Item No. **Report of the Head of Planning, Transportation and Regeneration**

Address THE BROADWAY 47 JOEL STREET EASTCOTE

Development: Erection of a three storey building to create a business unit and 1 x 2-bed residential unit involving demolition of existing store/garage to rear and remodelling of existing basement to increase business use

LBH Ref Nos: **17155/APP/2021/1453**

PL 02.01 C

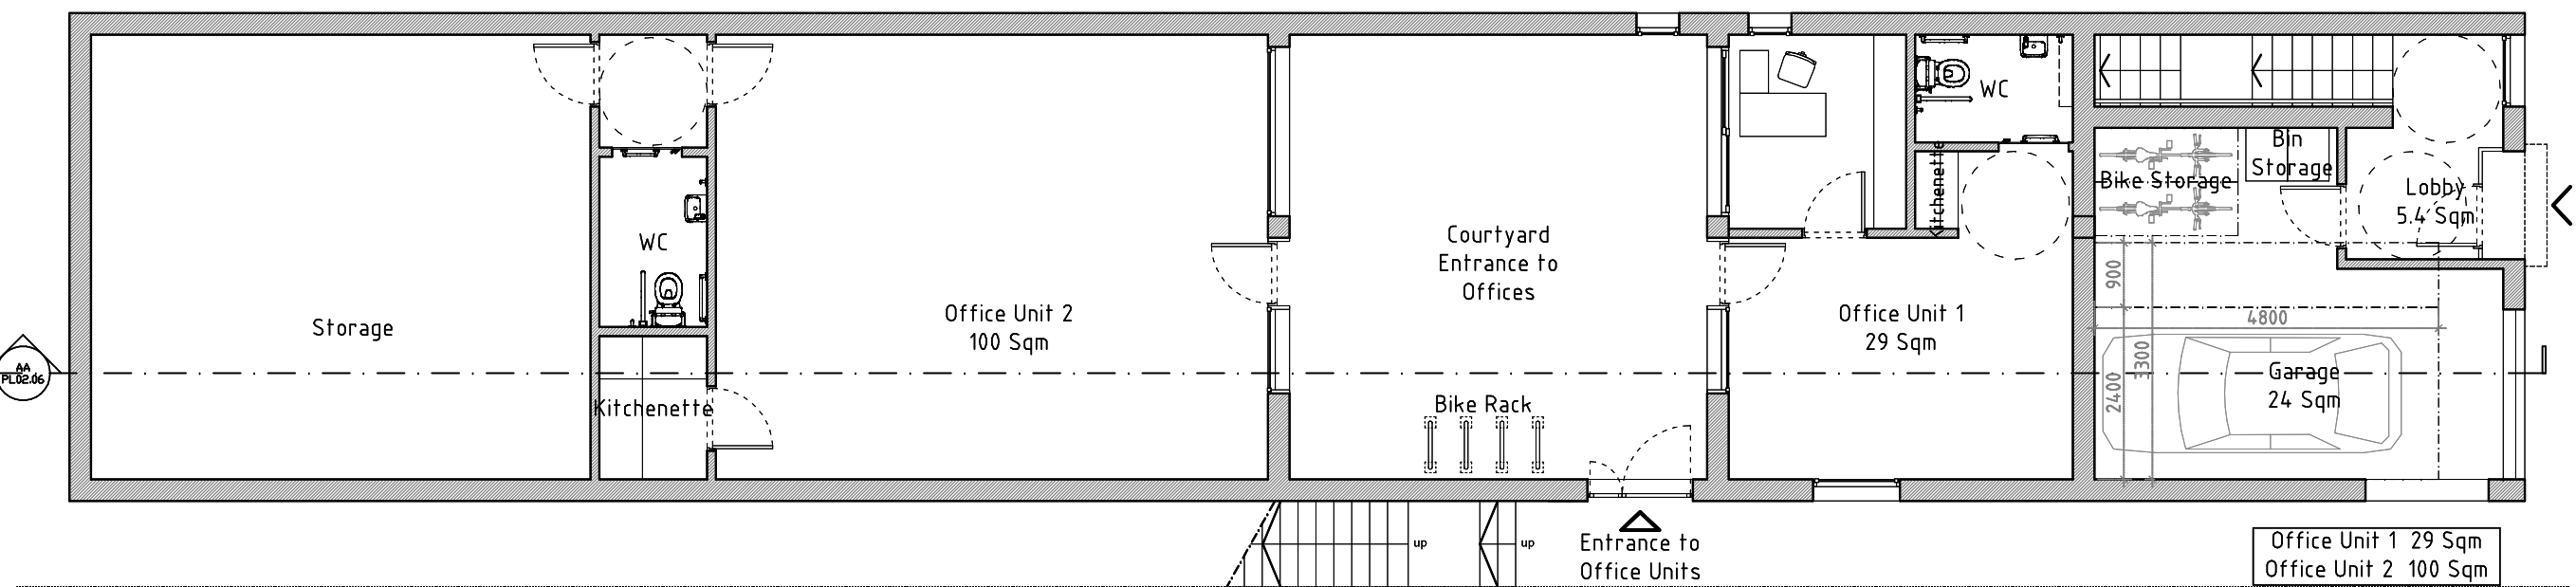
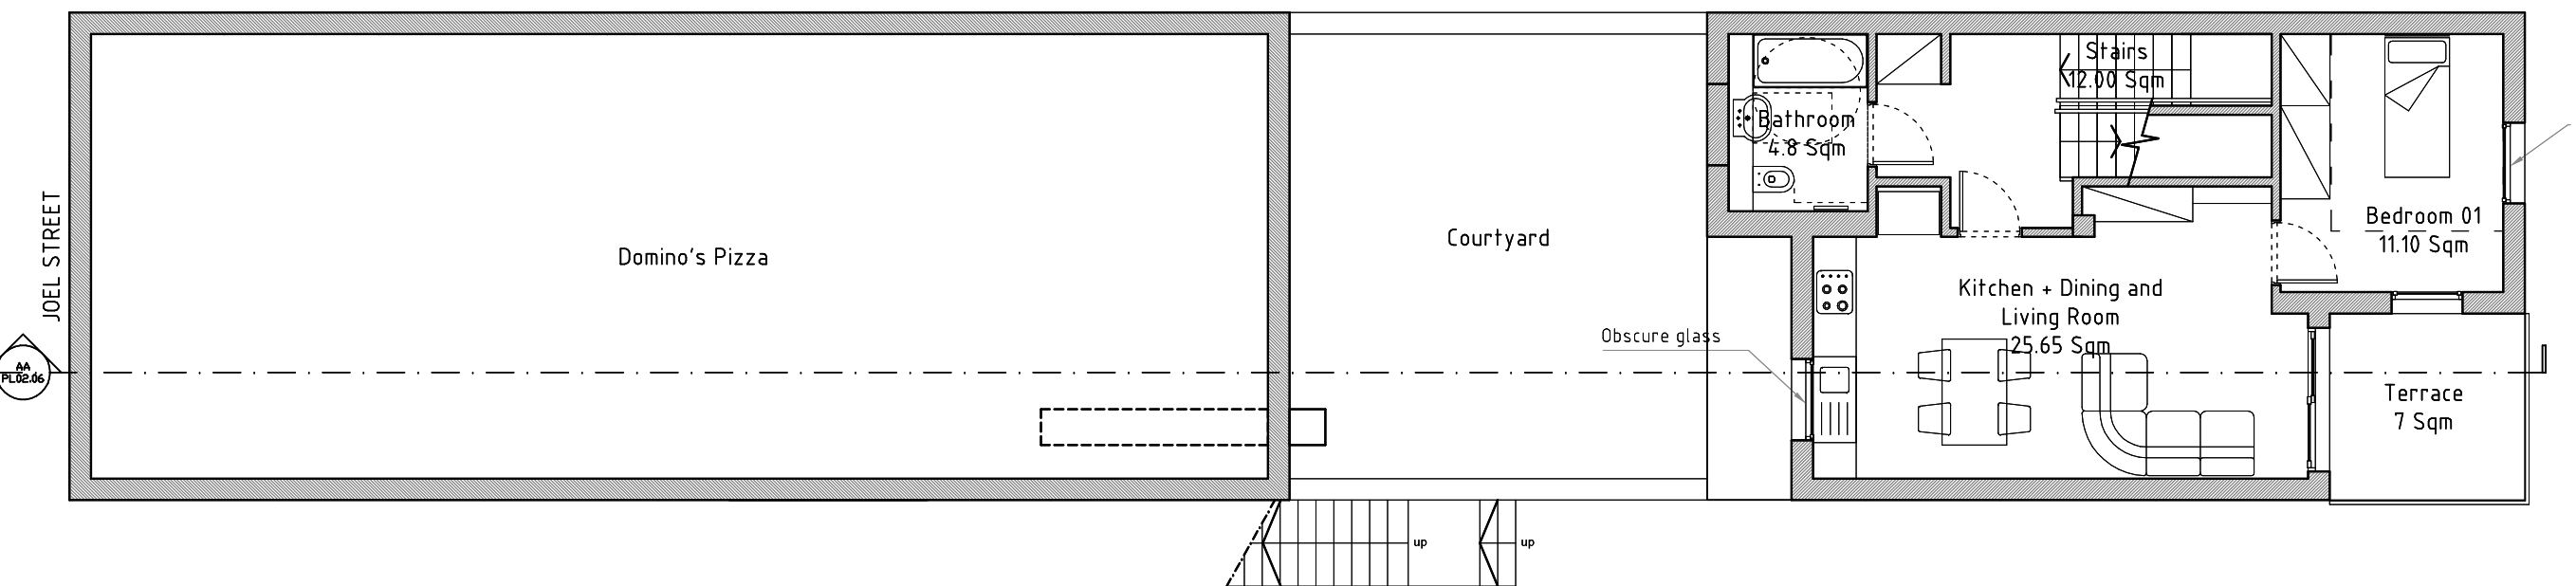
The bulk, massing and height of the development has been reduced. The previous application proposed a distance of approx 4.1 metres between habitable room windows at No. 47 and the development and this has been increased to approx 16.9m. It is considered that this distance would still be unacceptable and contrary to the Council's minimum requirement of 21m. Furthermore the development would still be only 8.9m from the terrace which forms part of the occupiers residential unit. As such it is considered that this development would cause harm to the amenity of residents at No. 47.

The development would also be only 10m away from the rear of No. 49 where there are two large habitable room windows and a terrace. As such it is considered that the development would cause harm to the amenity of residents of that property. This property abuts the existing 4 storey building at no 53-55 Joel Street, and as such already has a

restricted outlook. Given the scale and proximity of the development it is considered this would result in an overbearing impact on the amenity of the neighbouring occupiers.

The proposal includes a high level window serving a kitchen on its rear elevation facing the Joel Street properties. This would be obscure glazed to prevent any overlooking. It is noted that this kitchen would be served by a second window.

The proposed building would comprise a 3 storey mixed use block at a height of approximately 8.6m and a maximum width of 6.8m. Whilst the height of the building has been reduced since the submission of the refused application, its width is the same. The development would be set immediately adjacent to the road. This is a substantial building in a very prominent position, which would be an incongruous addition which would be unduly overly dominant and out of scale with the character and appearance of the area.

It is noted that the Design and Access Statement includes plans to demonstrate that a lift can be provided in the future if required. As the list does not form part of the proposal it is considered that refusal on accessibility grounds is warranted in this case.
